From: Maria Tomalova
Sent: Wednesday, July 6, 2022 10:21 AM
To: Peter Cleveland [REDACTED]
Subject: RE: Stakers Farm

We also discussed the DOC for the site Y/5/22/DOC. We would like further details regarding proposed material types e.g. manufacture and specific product with state allowance (or matching alternative if product not available). Martyn did point out that the plans submitted with this DOC were from the current architect rather than the previous who gained approval.

BARNs 1&2 PROPOSED SOUTH EAST ELEVATION
SHOWING SHUTTERS OPEN

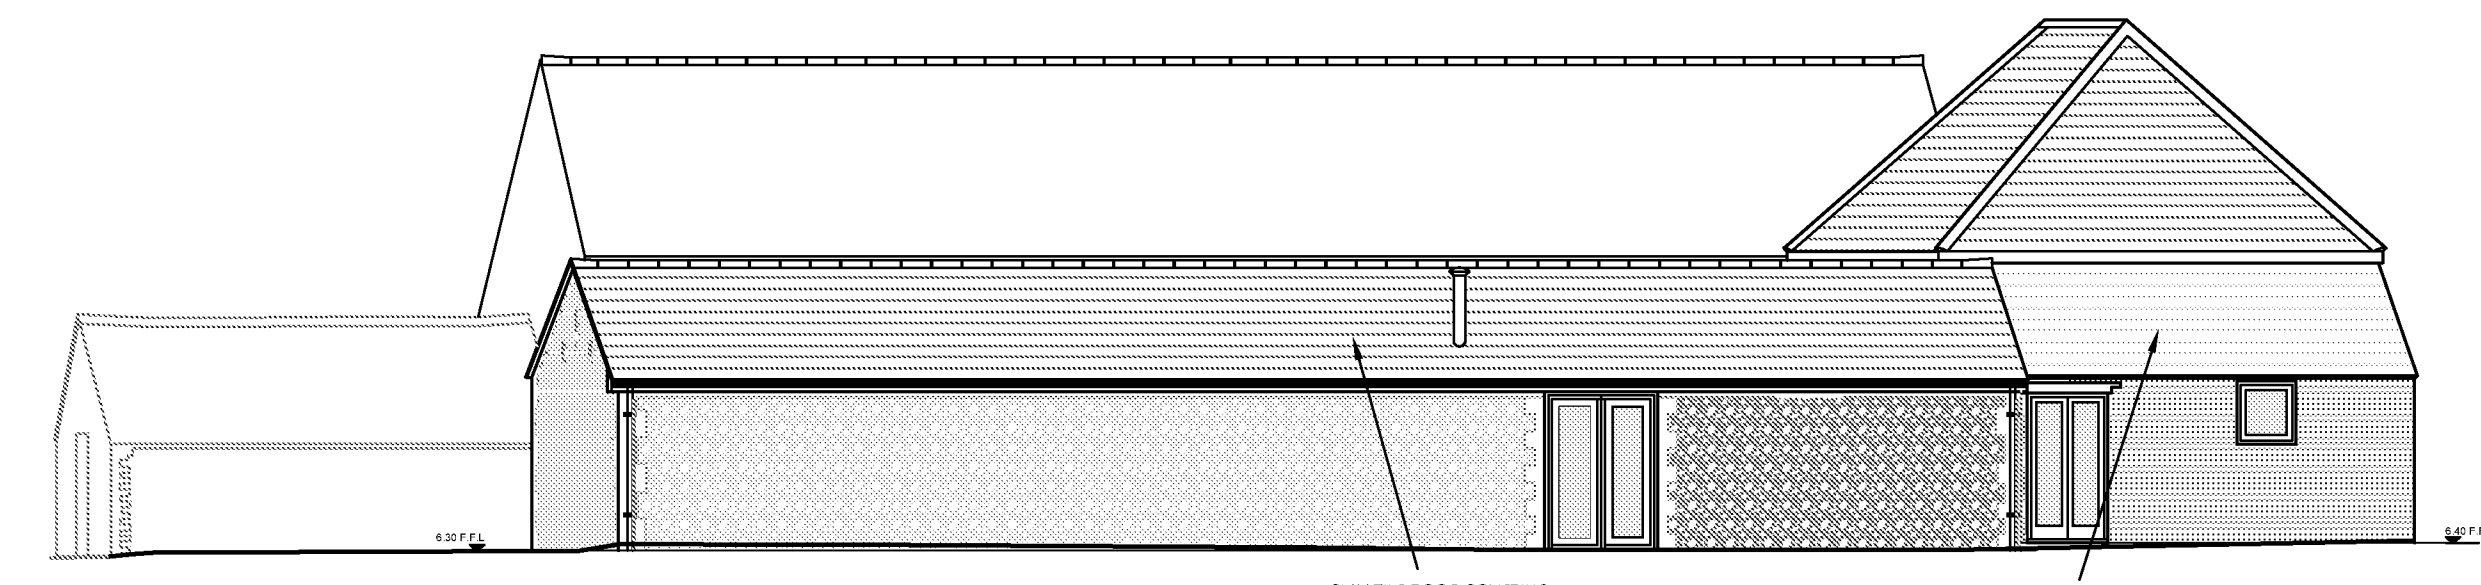
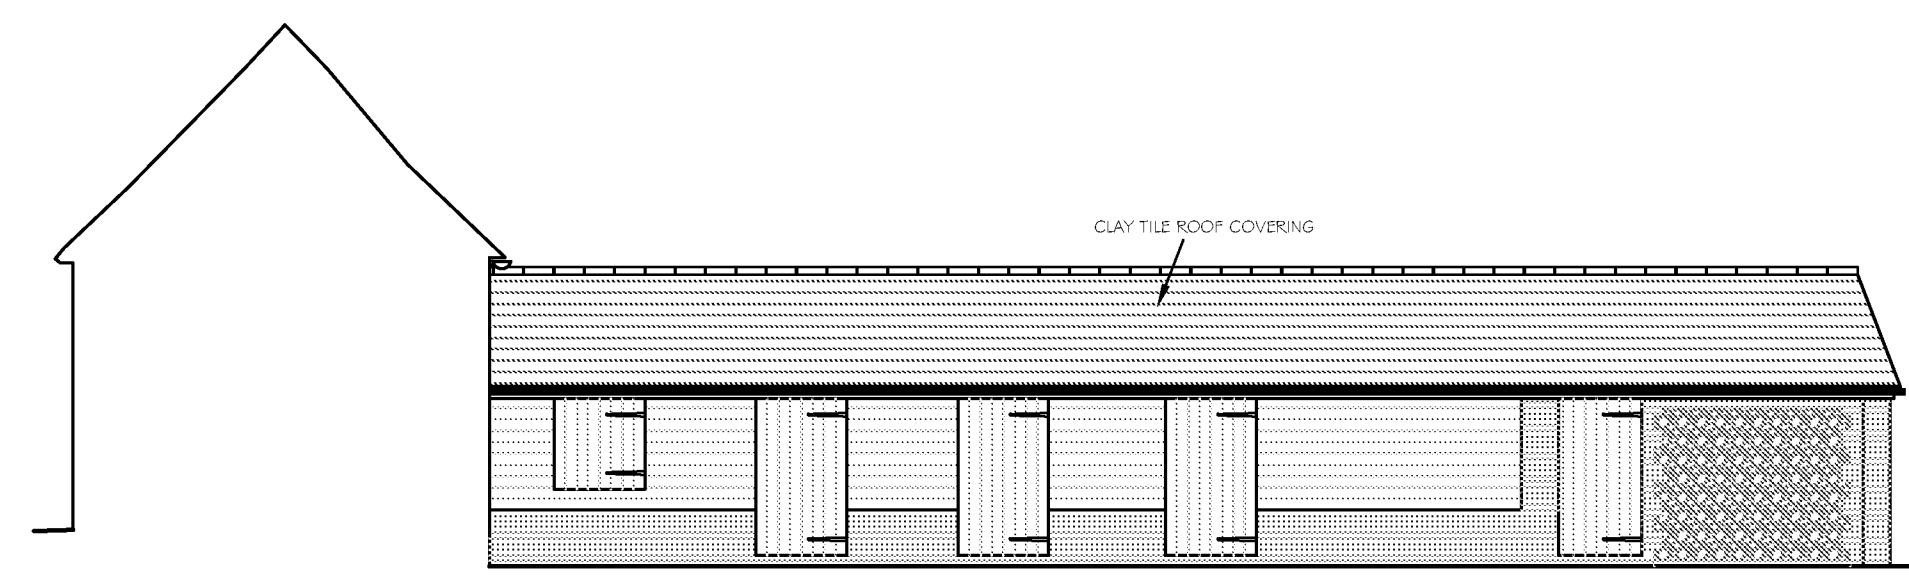
1. Altered proportions of window on the south-east elevation with the proportional split of openings to be circa 2/3 for the opening and 1/3 for the low level fixed frame
2. Width of fenestration on outshot to the side of the main barn reduced to 2 pane widths.

- Barn 2 potential for window to dominate the elevation - As shown on the attached photo, this is an original cart shed opening which has previously been crudely infilled with brickwork and a door. The original timber beam above the opening is still in position, and this will be retained and used as the top of the reinstated opening. The removal of the door and infilled brickwork will reinstate the original opening, and this will be clearly expressed with a simple, full height glazed screen.

- Barn 1 south east elevation - The proposed windows to the south east elevation of Barn One are all within existing openings and would all serve bedrooms. We have now omitted the horizontal boarding to the window serving bedroom 3 and shown this as full height glazing to match the other proposed windows. Can window details be dealt with via condition if needed?

BARN 2
PROPOSED NORTH EAST COURTYARD ELEVATION

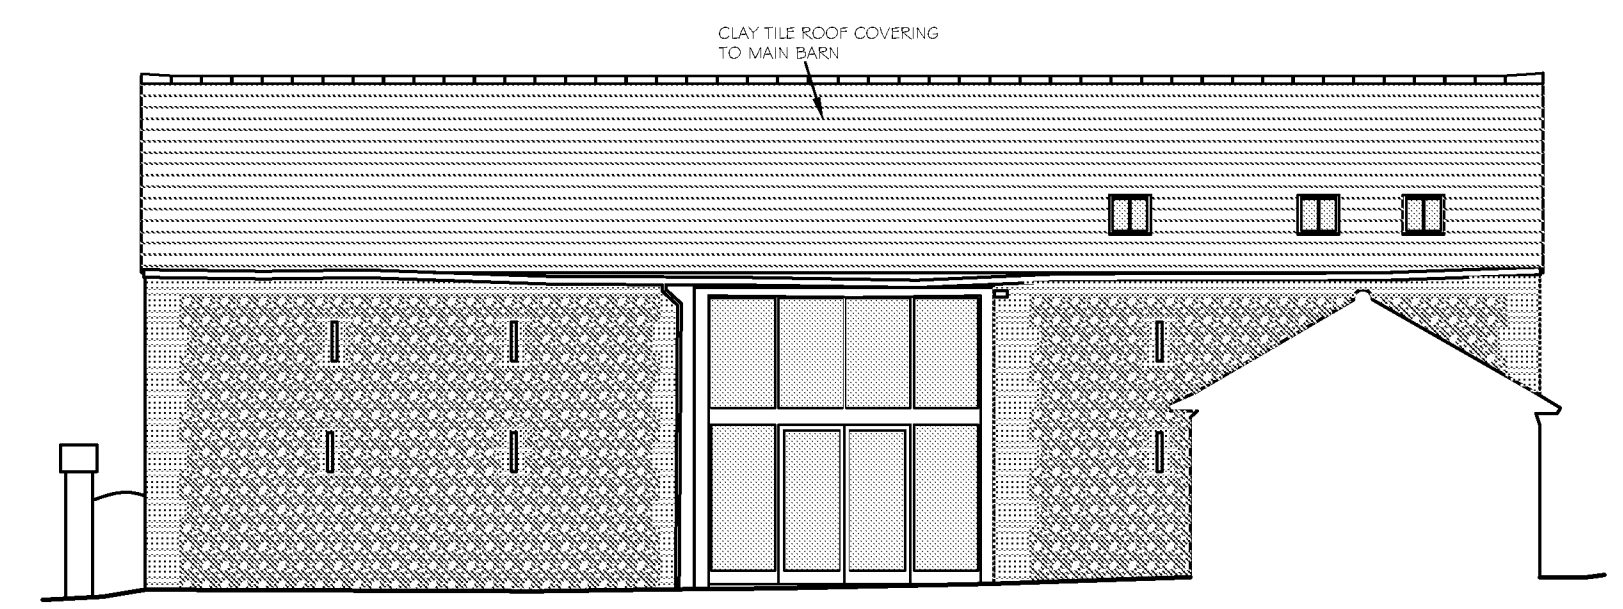
I have recently spoken with Martyn and we are the same opinion that from the attached drawings (27/06/22) it is not clear what this white colour of lintel mean.

If you ask the technician who made this drawings to put the note pointing at a lintel that this is an existing (without changes in colour) or will be replaced (if not in satisfying condition) for a like.

The element above the door is acceptable as you have described below – our concerns came from the way it had been presented on the plan. Brick surrounding the windows in that element is our preference. They should be good quality and match the existing.

In particular the concern related to the materials around the opening in the gap – (apparently wood whereas brick is the preference) and some understanding of what the strip is above the window and below the existing flint area with small window above.

Further to our call last week and the email below, please find attached the amended drawing which addresses the request for brickwork in the cart store opening. I hope this now addresses the comments from Martin.

In terms of the strip referenced. This is the existing lintel which will be retained as is. Please see photograph attached.
